FIVE ESTUARIES OFFSHORE WIND FARM

10.19 APPLICANT'S COMMENTS ON DEADLINE 1 SUBMISSIONS

Application Reference:	EN010115
Document Number:	10.19
Revision:	A
Pursuant to:	Deadline 2
Eco-Doc Number:	005416679-01
Date:	22 October 2024

SLR Cable drum vehicle
 Overall Length 25.660m
 Overall Width 3.000m
 Overall Body Height 4.900m
 Min Body Ground Clearance 0.427m
 Max Track Width 3.000m
 Lock to lock time 6.00s
 Wall to Wall Turning Radius 9.800m

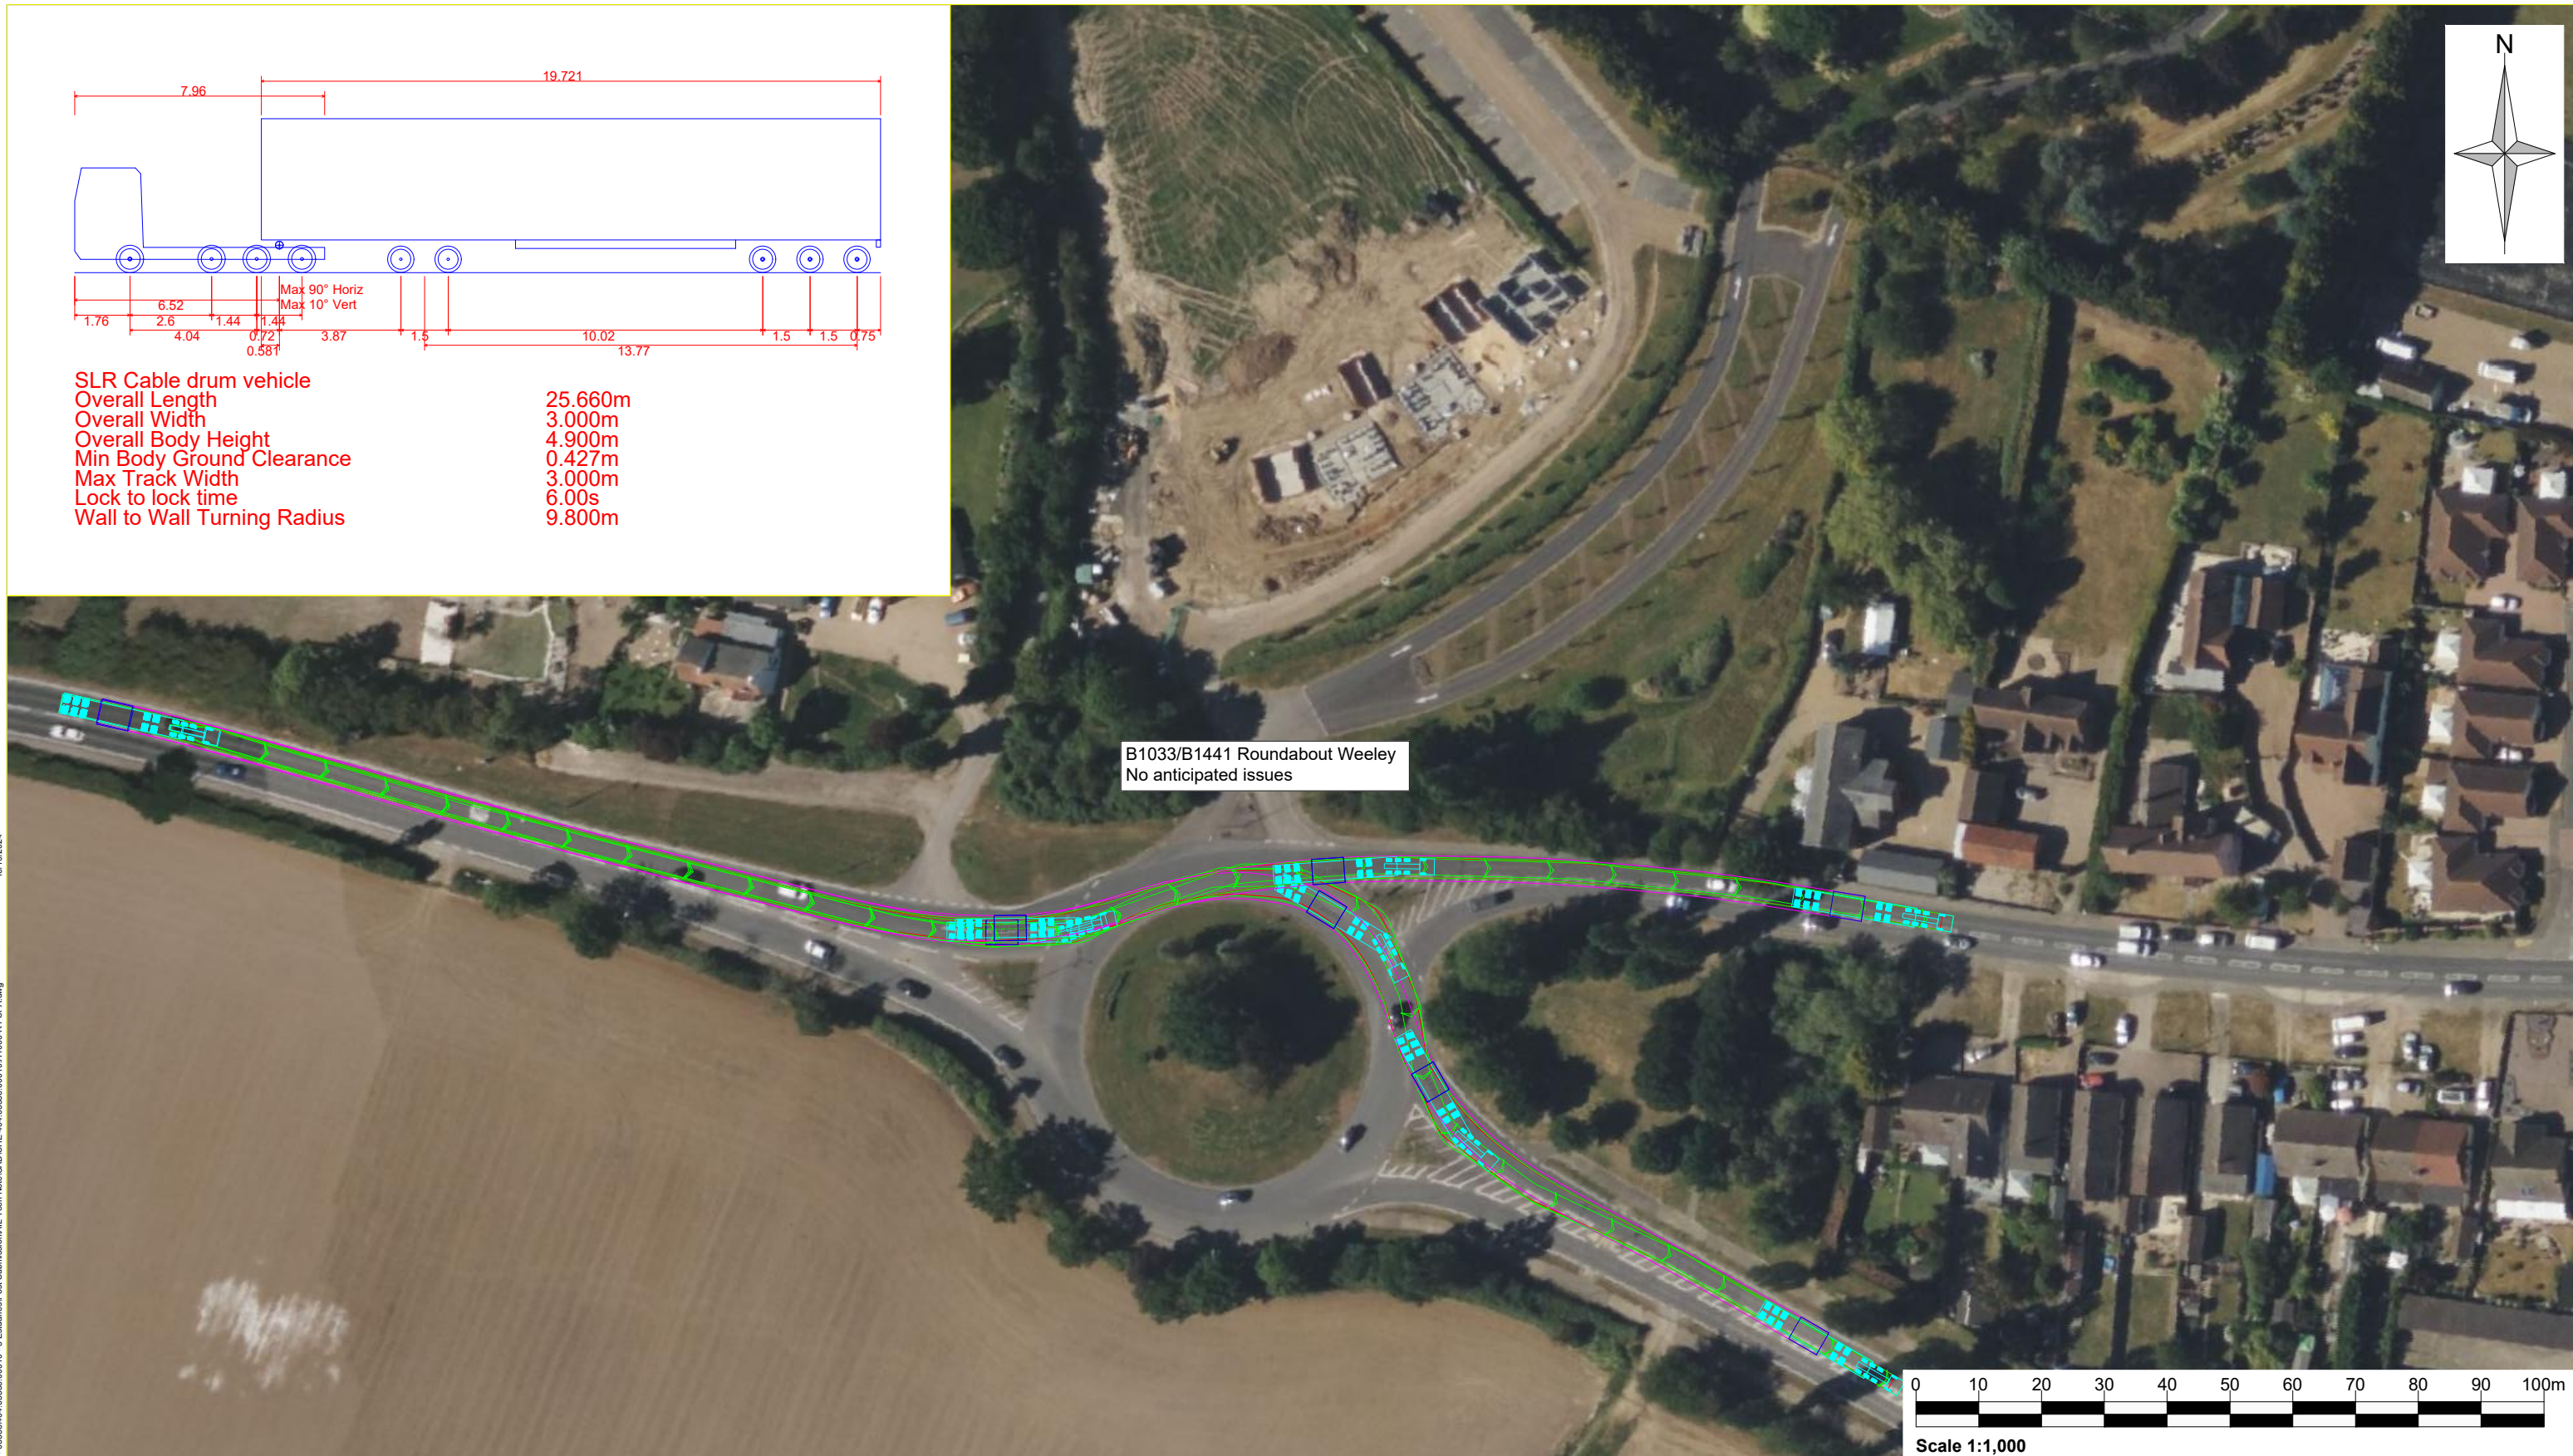
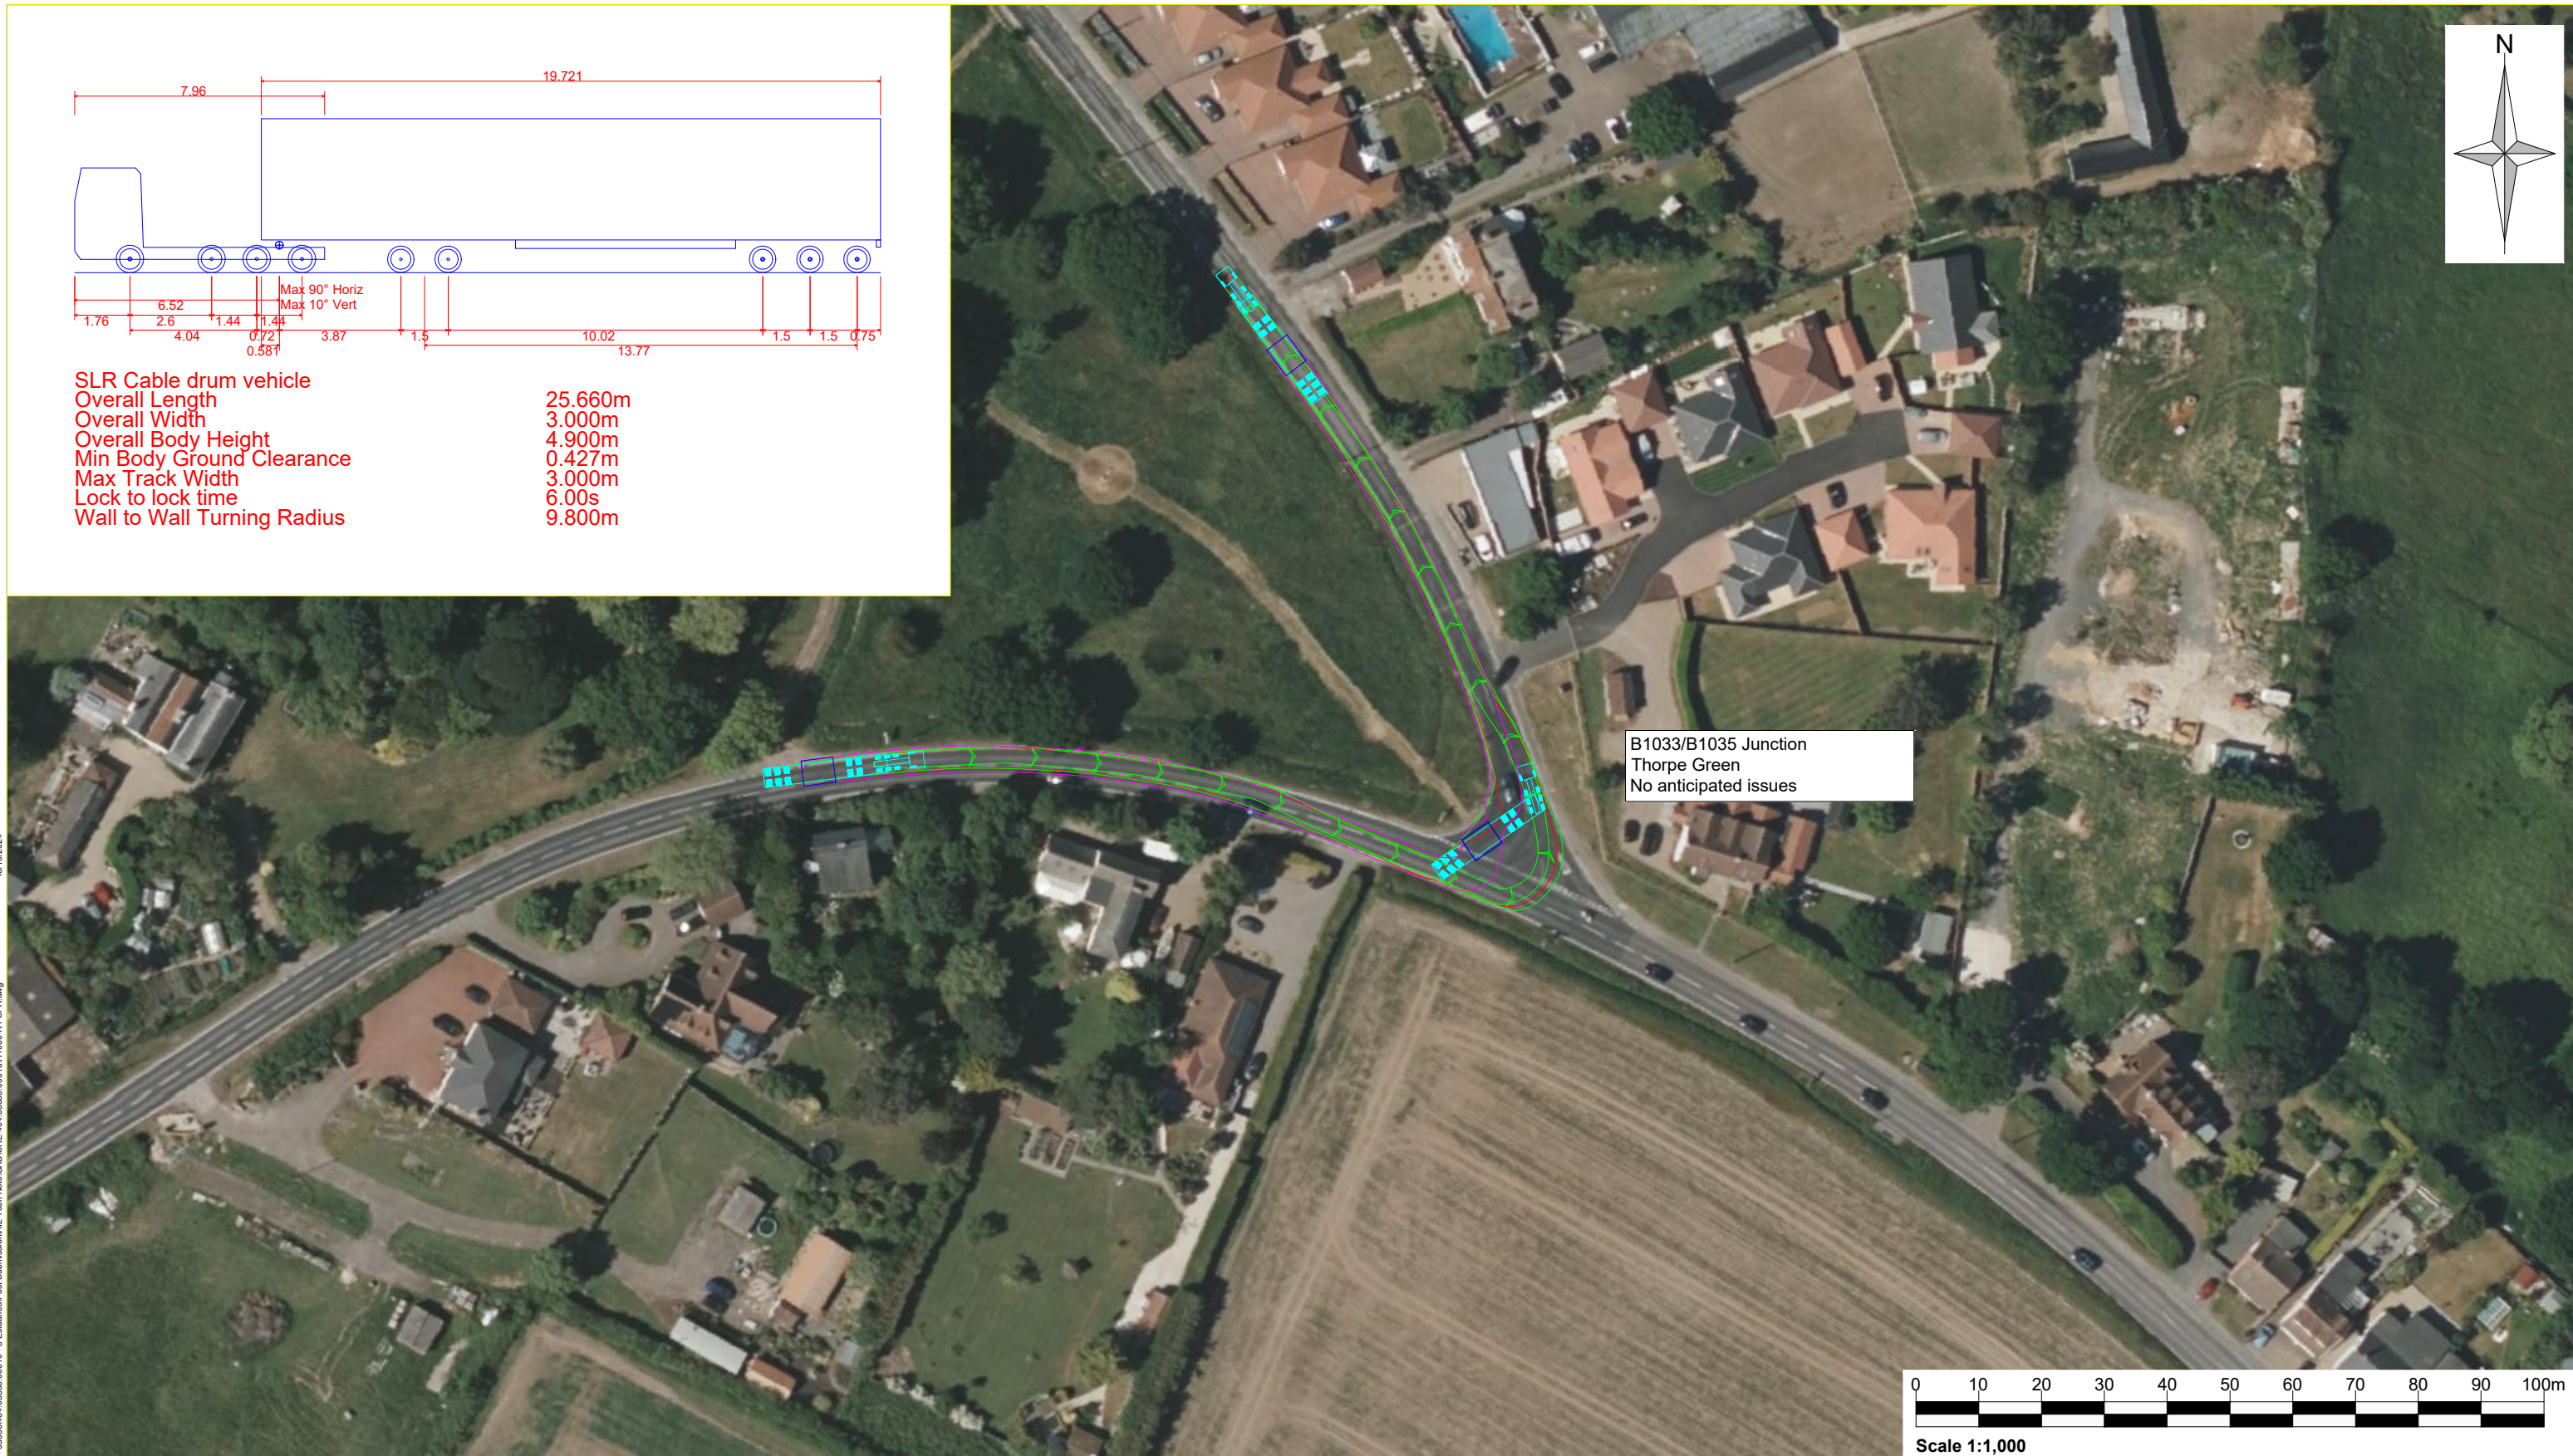
<p>AILs</p> <p>There is no reference to cable drum AILs within the Traffic and Transport chapter [APP-090], but it became clear at ISH1 that there is a requirement for these to access the proposed accesses on the rural road network. There are concerns around the routes for AILs for these cable drums associated with all of the accesses on the route, particularly the number and frequency. Clarity is sought on what assessment has been undertaken of the routes, including whether a structural assessment has been undertaken to ensure the deliverability of their routes i.e. can the local road</p>	<p>The Applicant has prepared an Abnormal Indivisible Load (AIL) Technical Note, which is being submitted at Deadline 2. This includes swept path analyses of the largest likely cable drum delivery vehicle on the highway network.</p> <p>There would be an estimate of 280 to 290 cable drum vehicle movements, which are included in the forecast construction vehicle movements set out in the Traffic and Transport chapter [REP1-018].</p>

network accommodate these movements. If an assessment has not been undertaken of the routes, it may be that they are not deliverable, and so would have to use alternative routes with different impacts. This presents a risk to the project. We would request that swept path drawings are provided at key junctions along these routes, and structures pinpointed along the designated routes with assessments undertaken of those structures.
